From: Neal Chantrill <Neal.Chantrill@leics.gov.uk>
Sent: 27 June 2022 10:45
To: Thomas White <tom.white@blaby.gov.uk>
Cc: Victoria Vernon <Victoria.Vernon@leics.gov.uk>
Subject: 22/0105/VAR and 22/0506/FUL - Green Acres Aston Lane Aston Flamville Leicestershire LE10 3AA

It appears that the site layout previously approved has not been implemented. It also appears that gates have been installed that open into the 2 car parking spaces adjacent to the highway. It is also noted that Google aerial view demonstrates inconsiderate car parking due to a lack of de-lineation.

PROPOSED PLAN

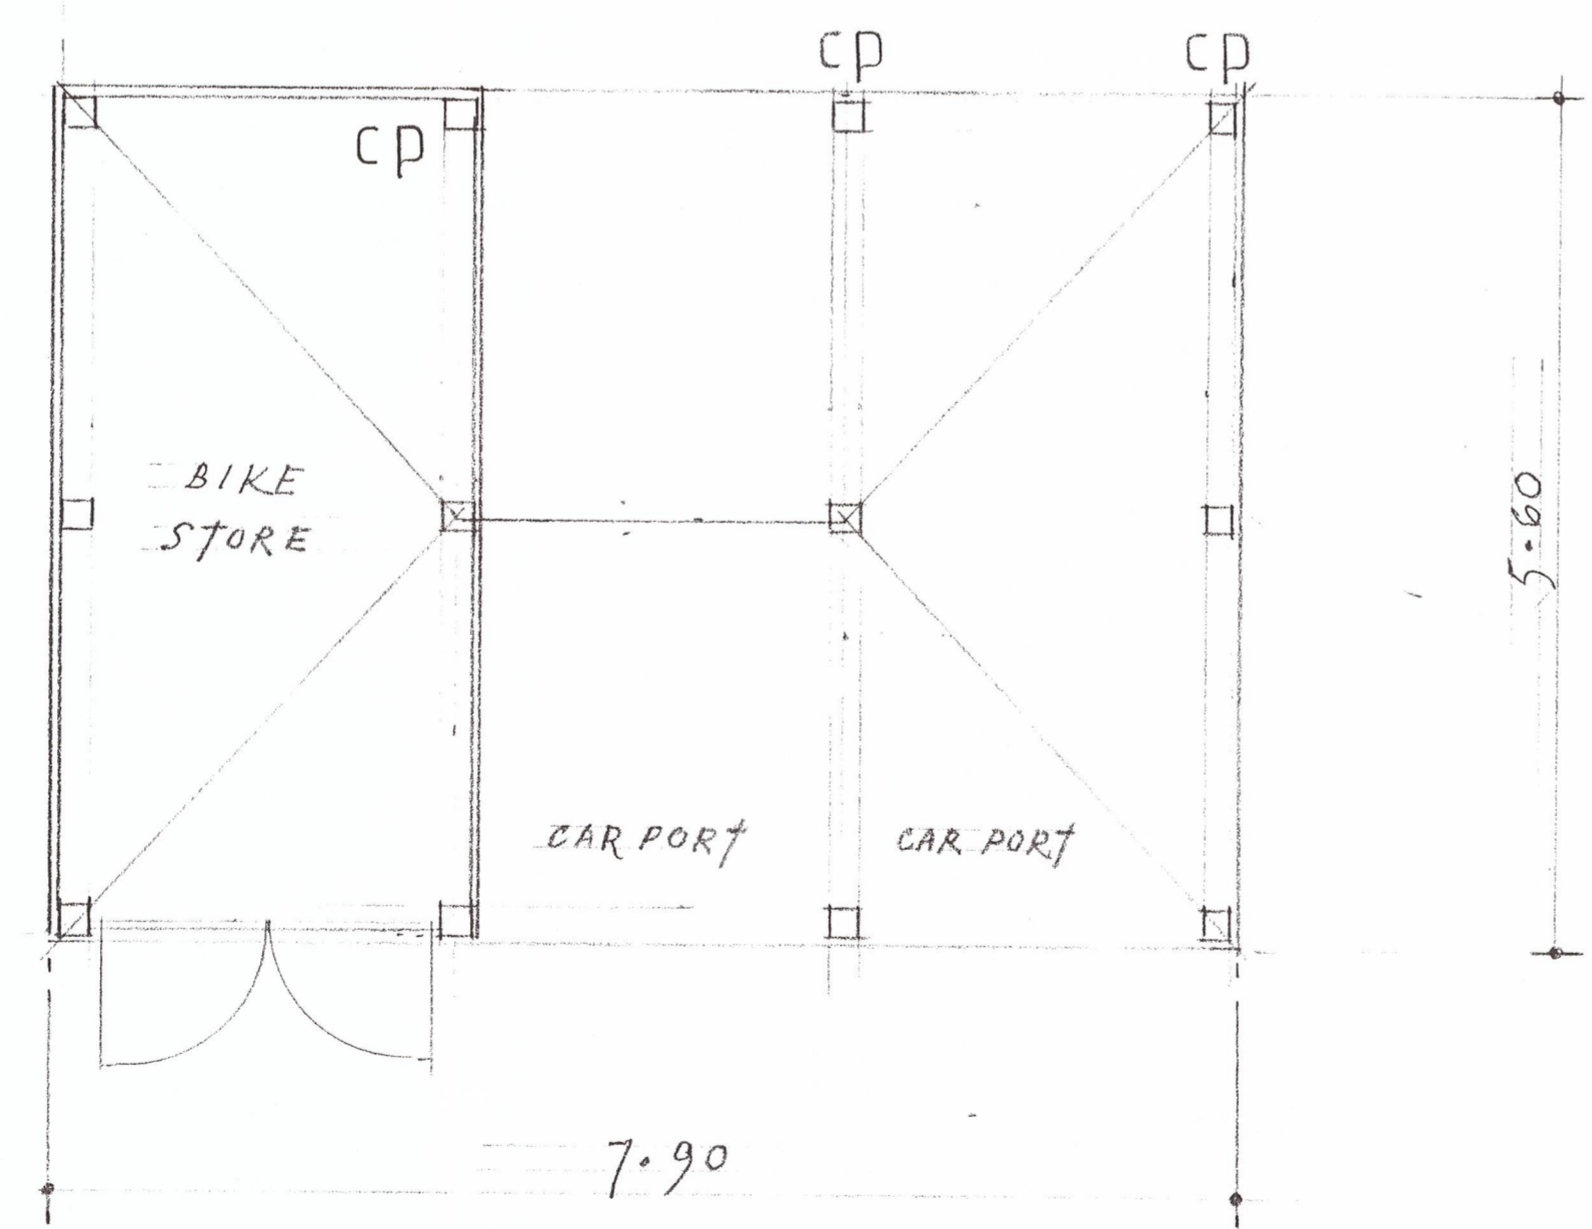
As such the LHA concerned that parking has not be laid out in accordance with the plan. Given the existing gates would impede the use of at least 2 of the approved spaces and the LHA would want to seek clarification over whether the applicant intends to implement this access or whether the LHA are assessing the application based on the access which has been built? In which case the LHA would need to fully assess the appropriateness of the existing access.

Given the above, and without the proposed increase being supported by a parking accumulation study to evidence sufficient parking is available despite there being a loss against the approved drawings, I'd be cautious over any increase which could lead to overspill onto the existing highway in this location.

It is also noted that within the documentation for both 22/0105/VAR and 22/0506/FUL, the car park has been described as have 16, 17 and 18 existing spaces, the Applicant should clarify situation.

In terms of 22/0506/FUL, given this is a business tandem car parking is not encouraged, the gates for the cycle parking would also open into the one of the car parking spaces.
